Our Ref: P/38/20/DOC

Approval of details reserved by condition imposed under ref P/70/19/RES relating to Condition Nos 4 - paved & gated access, 6 - charging of electric vehicles and 9 - new signage to encourage responsible dog ownership.

Land To North of Summer Lane Pagham PO21 4NG

Arun District Council have decided to **REFUSE details reserved by condition for the following reasons:**

Foundation Plan

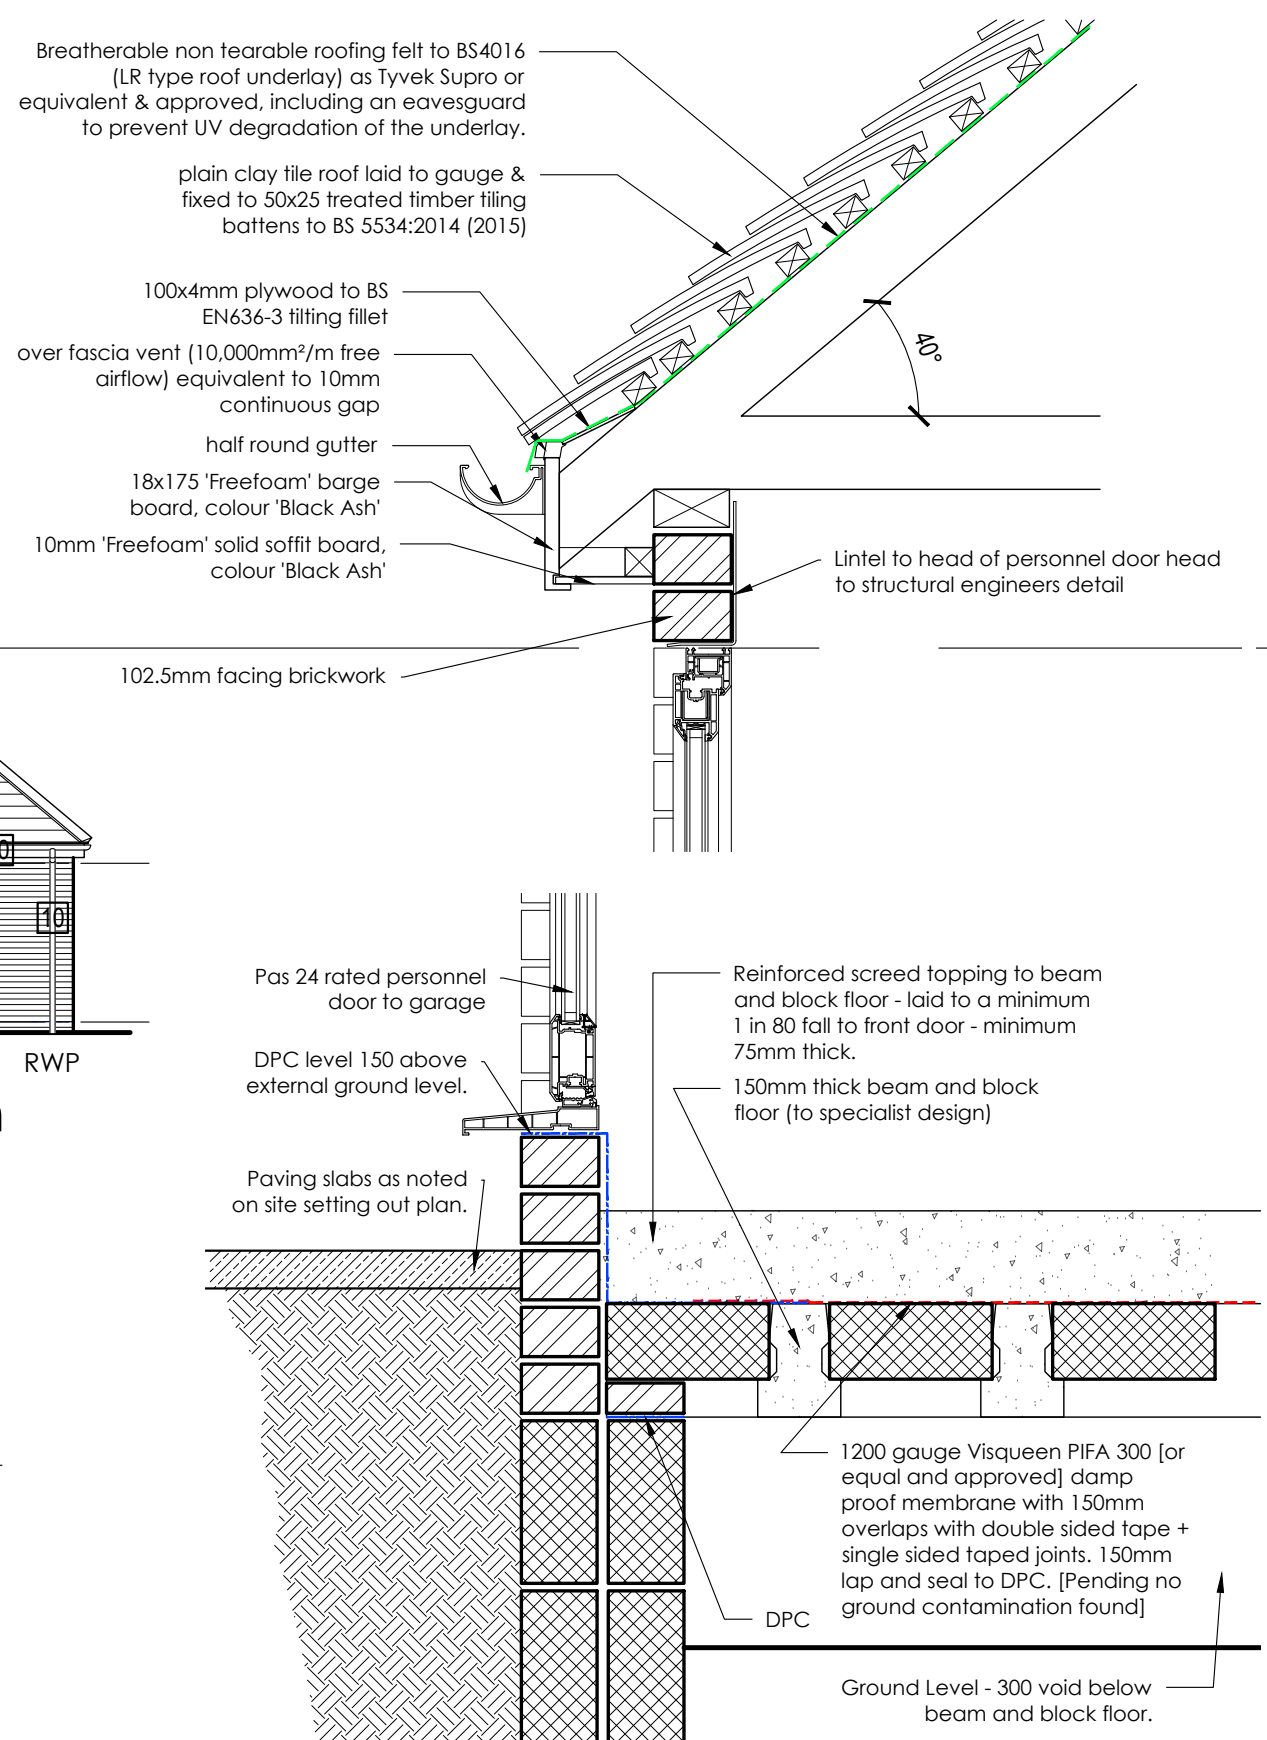
The details submitted in respect of the electric car charging points namely the proposal to provide all 29 garages with an active point and all other remaining spaces with passive provision (as shown on "Site Over View Plan with Sub Structures Indicated" ref 1177-WD-132 Rev A & "Garage Details - 1" ref 1177-WD-732 Rev B") and confirmed by email of 18 May 2020 (10:39am) have not been accepted.

Whilst I acknowledge that your proposed number of active points in garages is in accordance with how the SPD is currently written, we have stated that there is a typo in the document and that an active point should in fact be provided for all houses with either garage or driveway. Furthermore, it remains clear that you fail to comply with the 20% of all other spaces requirement.

The requirement within the Councils Parking Standards SPD is for

- 100% of parking spaces of houses with a driveway or garage to have an active charge point (this

- Until 2023, 20% of all other parking spaces should have an active point; and
- Ducting is provided at all remaining spaces where appropriate to provide passive provision for these spaces to be upgraded in future.
